**Consultation Response from KC,
Lead Local Flood Authority**

2020/93954 Land at, Lingards Road, Slaithwaite, Huddersfield, HD7 5HY

Erection of 43 dwellings and associated works

Date Responded: 25th January 2023

Detail
EXISTING SEWER INFORMATION

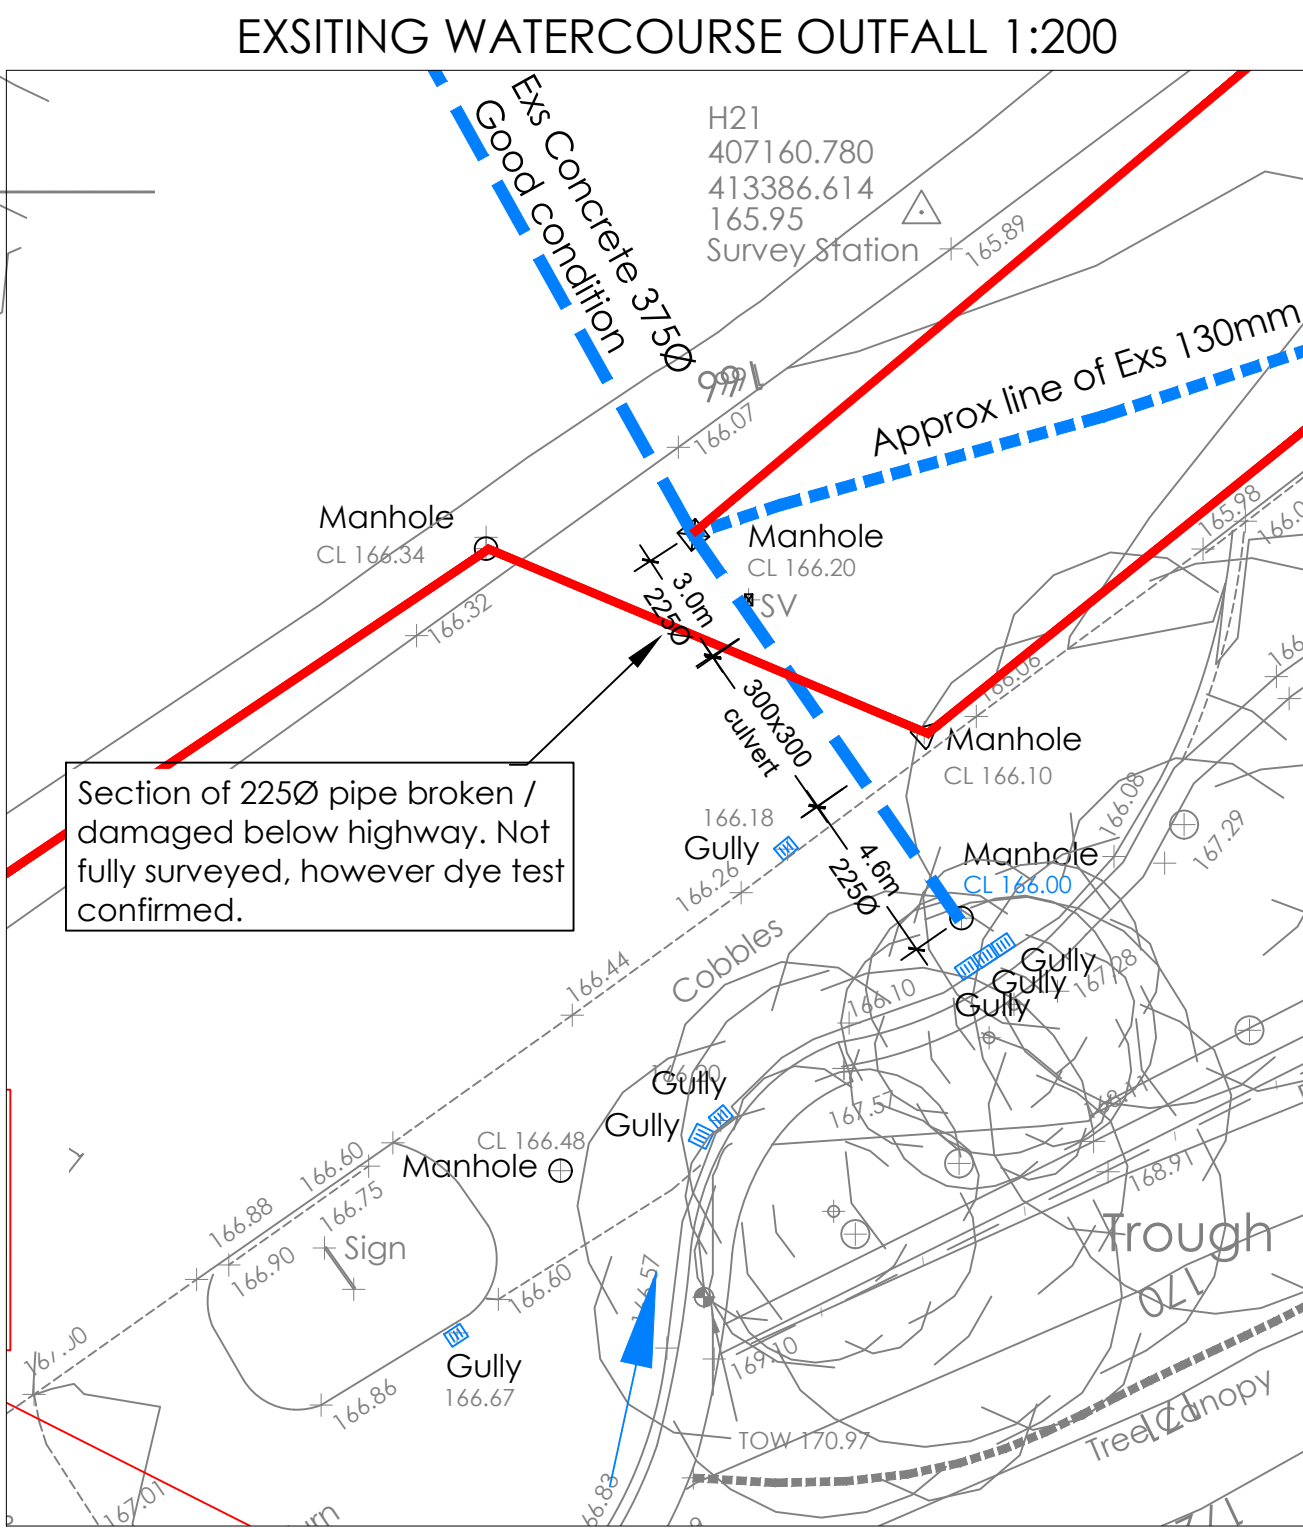
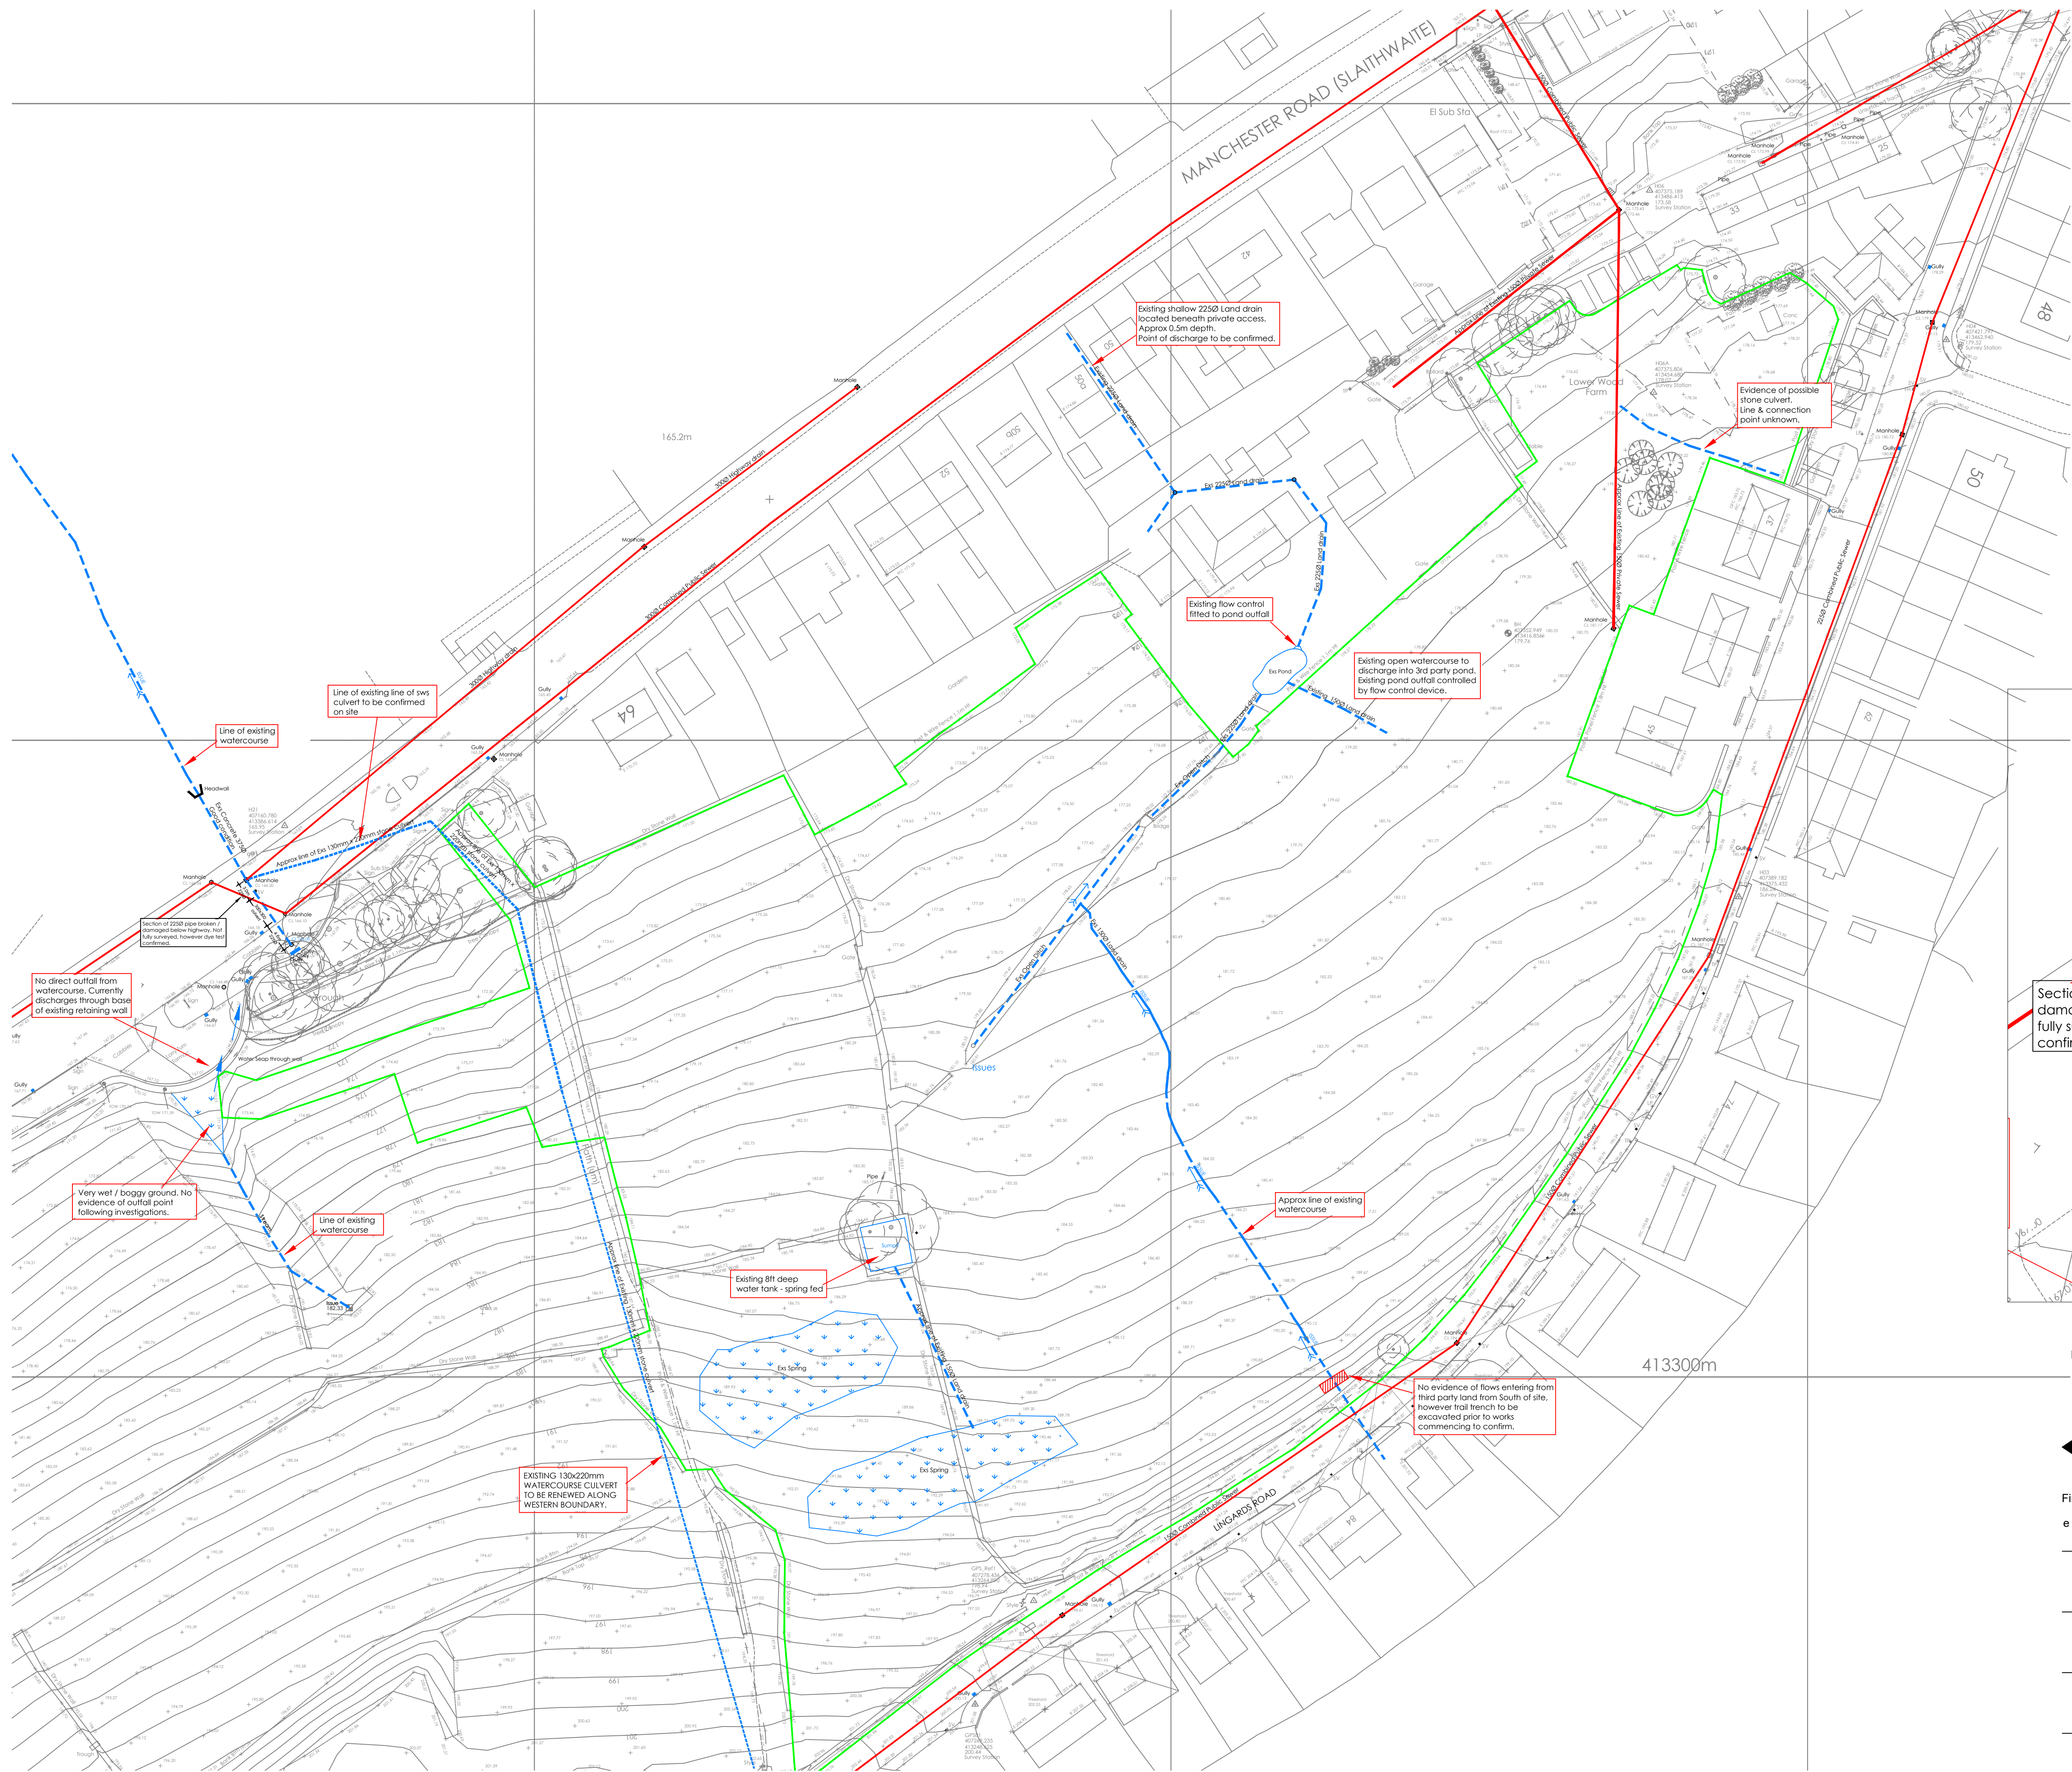
Kirklees LLFA has no objection to a 3l/s connection to public combined sewer for the low part of the site adjacent to the north-eastern border.

A full CCTV survey of watercourses and other systems located in Manchester Road has been carried out.

An offsite renewal programme of watercourse(s) within Manchester Road is accepted in principle. A detailed design incorporating long sections, and finalising optimum connection points can be dealt with via condition. Incorporating existing highway connections can be negotiated separate to this application with the LLFA and Highways Authority.
